TRUSS: A2
JOB ID: 72513620
DELIVERY DATE: 9/8/2025

SUBDIVISION/MODEL: LEANDER LEE PRESERVE
LOT #: 65

DELIVERY ADDRESS: 174 HARRIETTE COURT
LILLINGTON, NC 27546

REPAIR ID: MII-REP01A1 (ATTACHED)

Job 72513620	Truss A2	Truss Type Truss	Qty 5	Ply 1	MUNGO HOMES - TELFAIR C ROOF Job Reference (optional)
-----------------	-------------	---------------------	----------	----------	--

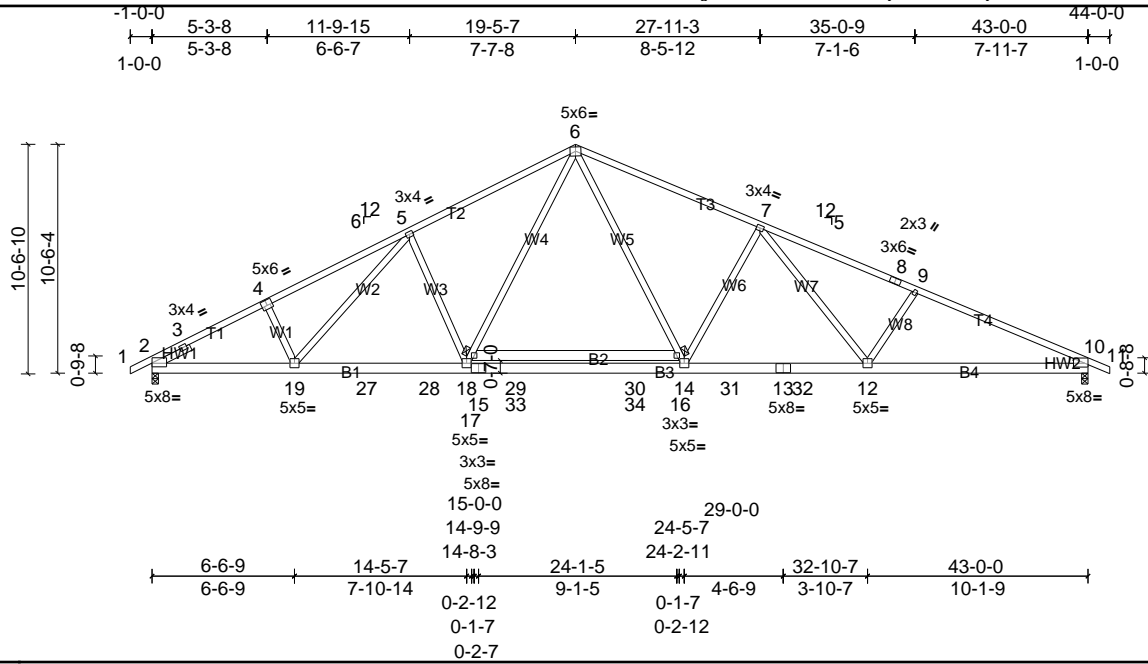
ATTACH 2x_ SCAB OF THE SAME SIZE AND GRADE AS THE BROKEN MEMBER TO EACH FACE OF THE TRUSS (CENTER ON BREAK OR SPLICE) WITH 10d (0.131" X 3") NAILS (TWO ROWS FOR 2x4, THREE ROWS FOR 2x6) SPACED 4" O.C. AS SHOWN.

STAGGER NAIL SPACING FROM FRONT FACE AND BACK FACE FOR A NET 0-2-0 O.C. SPACING IN THE MAIN MEMBER. USE A MIN. 0-3-0 MEMBER END DISTANCE.

THE LENGTH OF THE BREAK (C) SHALL NOT EXCEED 12". (C=PLATE LENGTH FOR SPLICE REPAIRS)
THE MINIMUM OVERALL SCAB LENGTH REQUIRED (L) IS CALCULATED AS FOLLOWS:

THE LOCATION OF THE BREAK MUST BE GREATER THAN OR EQUAL TO THE REQUIRED X DIMENSION FROM ANY PERIMETER BREAK OR HEEL JOINT AND A MINIMUM OF 6" FROM ANY INTERIOR JOINT (SEE SKETCH ABOVE)
